The Bluebird Cafe, South Drive
Ferring – Application ref. FG/159/18/PL

Project Reference: 1811-18/TN/01

Technical Note

- 1.1 Transport Planning Associates has been commissioned by Arun District Council to review a planning application for an extension to the Bluebird Café in Ferring. The application proposes to increase the size of the café from 188m² to 462m² (based upon the figures in the planning statement). This will result in an increase in floor space to approximately 2.5 times its current size.

02 Proposed Site Plan
1002 Scale: 1:200

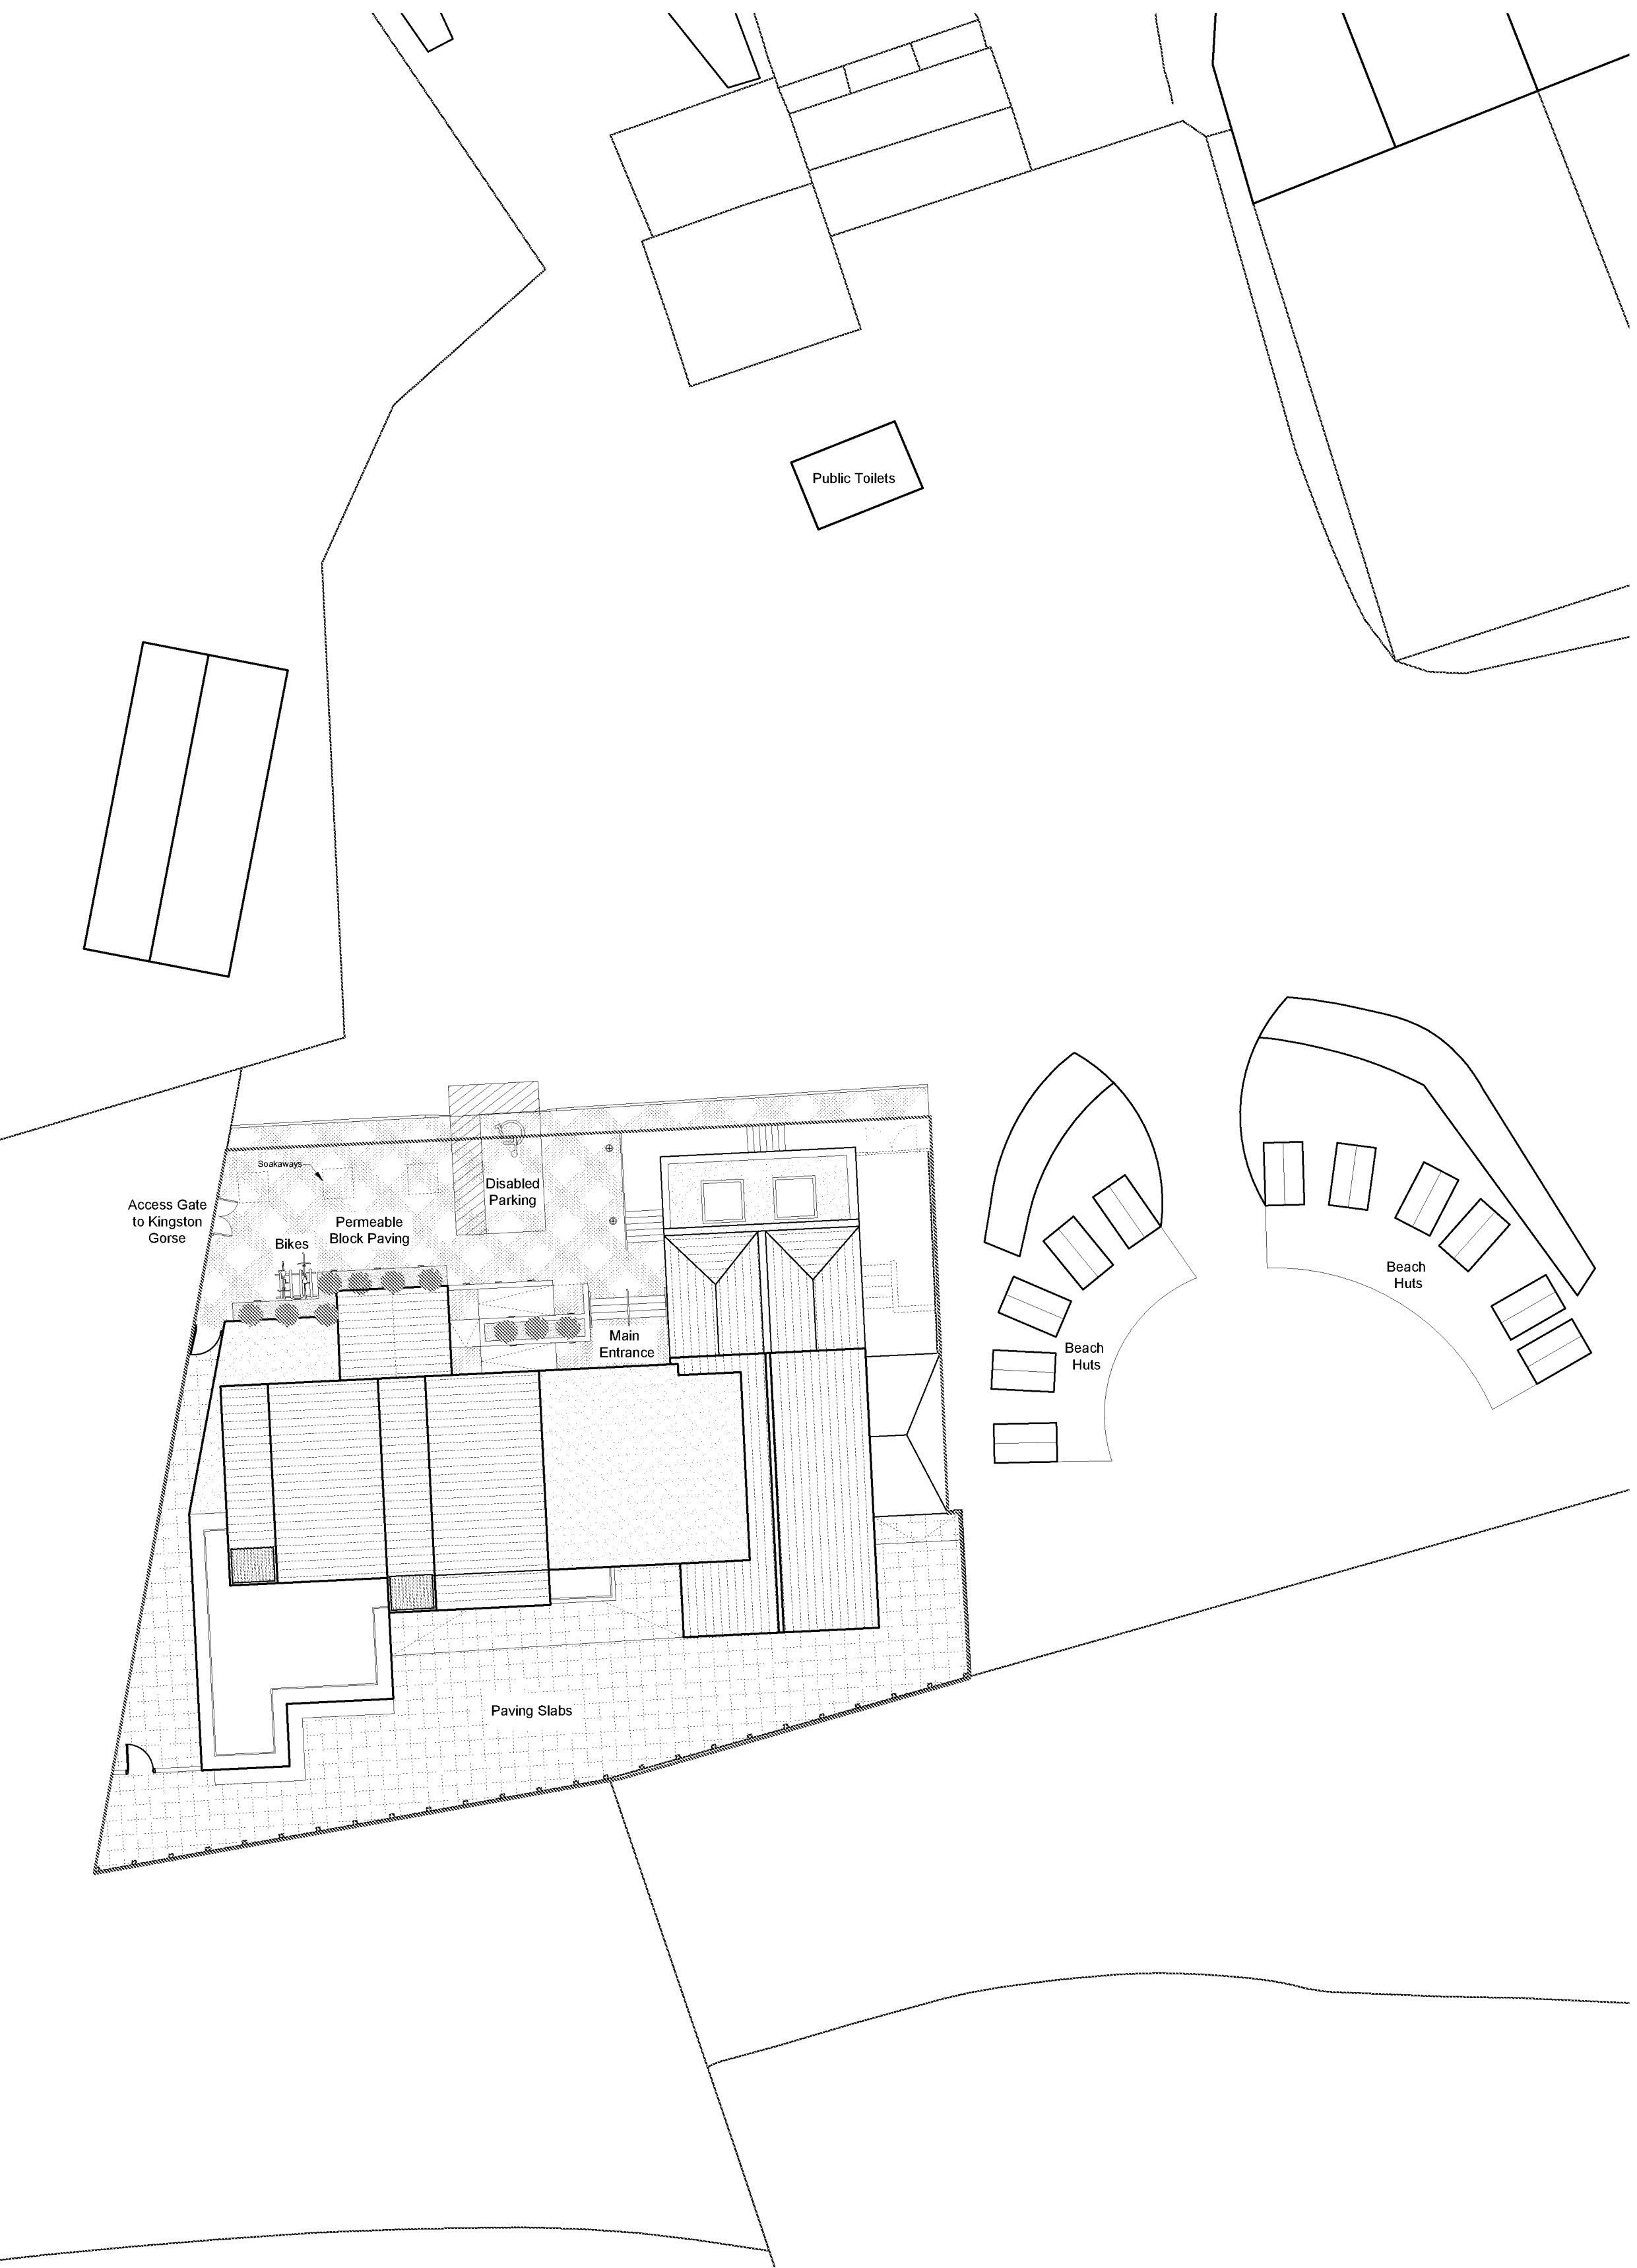
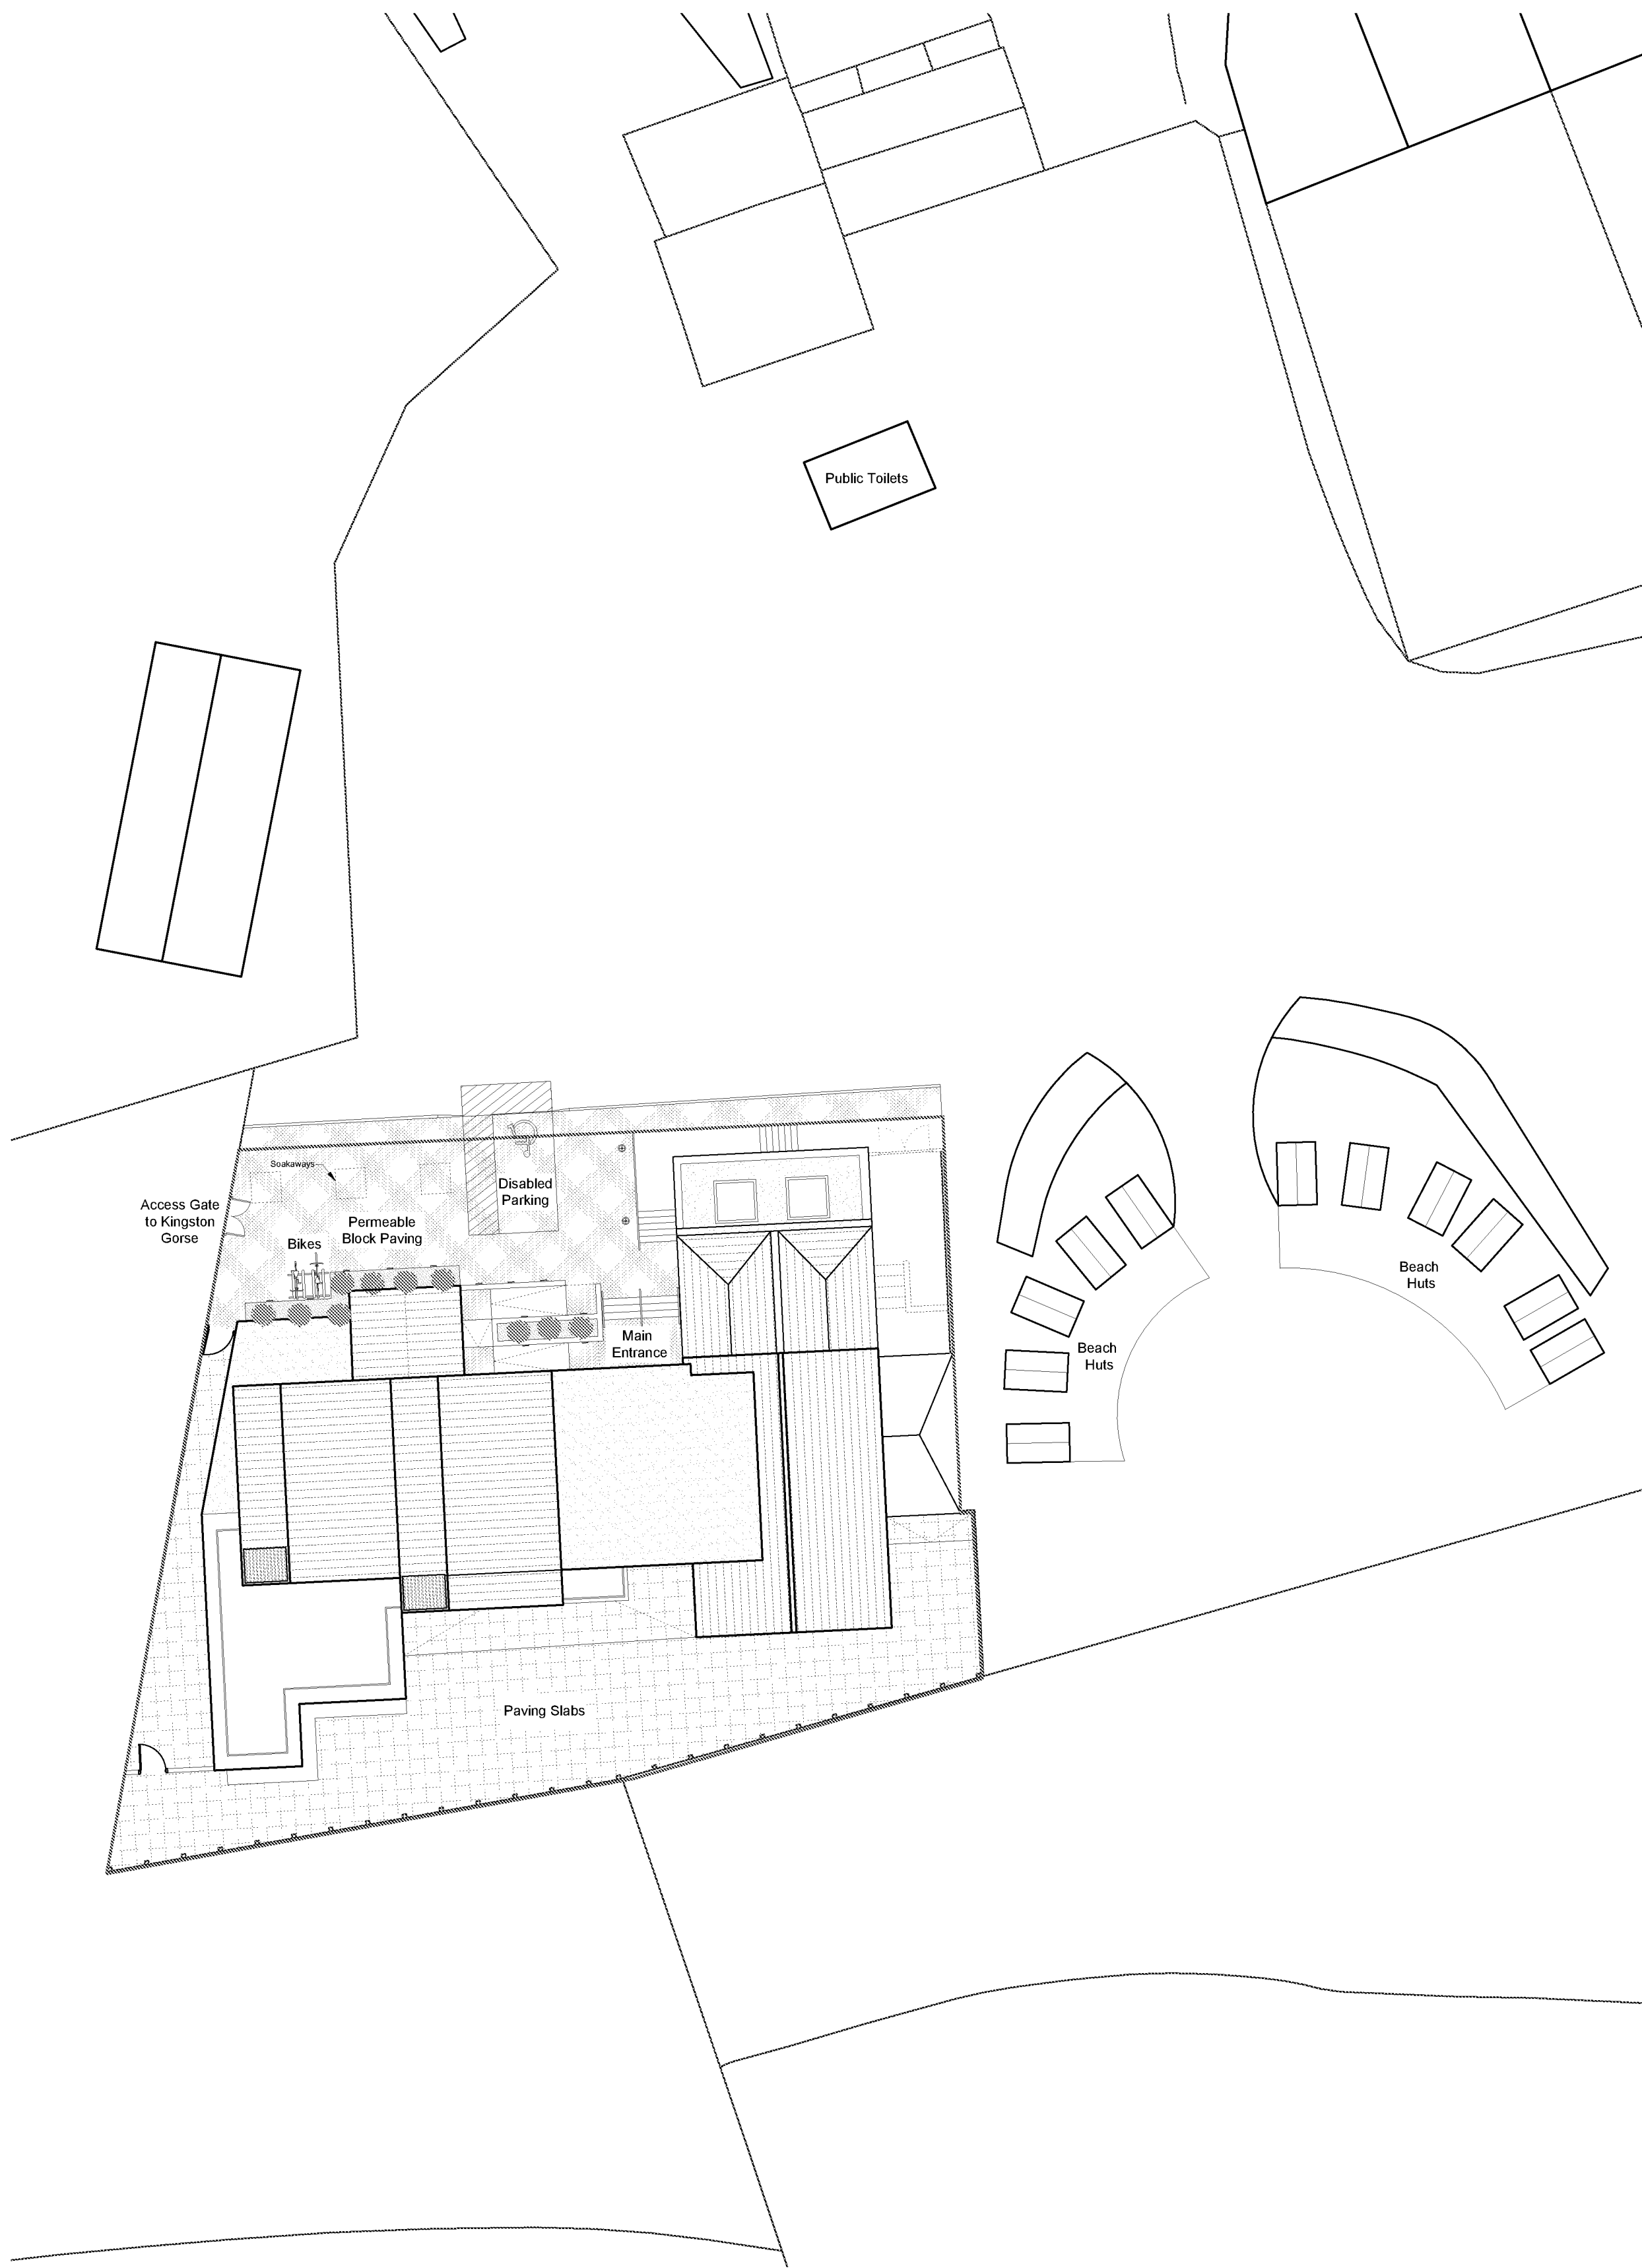
- 2.1 The site is accessed via a narrow private road, leading from South Drive to the shared car park area which serves the beach, beach huts, the application site and associated facilities. The access road is approximately 55m in length and its width allows for one way traffic only. The access road does not include any dedicated provision for pedestrians and is bound by walls on both sides.

- 2.2 Visibility splays at the junction with South Drive appear to be limited to the east and the Transport Statement does not provide any analysis of the available splays and their accordance, or otherwise, with current guidance.

- 2.3 Where the access road meets the car park it is bound by walls on either side which appear to limit visibility splays between traffic entering and exiting the car park. This is not reviewed in the Transport Statement provided with the application and it is considered that there is potential for collisions due to the limited visibility. The lack of any pedestrian facilities combined with limited visibility is a particular concern as the proposals will intensify the use of the access.

- A review of visibility splays at the access onto South Drive and where the access road meets the car park.
- Surveys of existing traffic using the access road, including vehicles and pedestrians.
- Traffic generation and parking demand calculations based upon summertime surveys of the existing site, or the TRICS database.
- Surveys of car park usage (occupancy) during summer months, to illustrate how much spare capacity exists and whether or not additional demand can be accommodated.
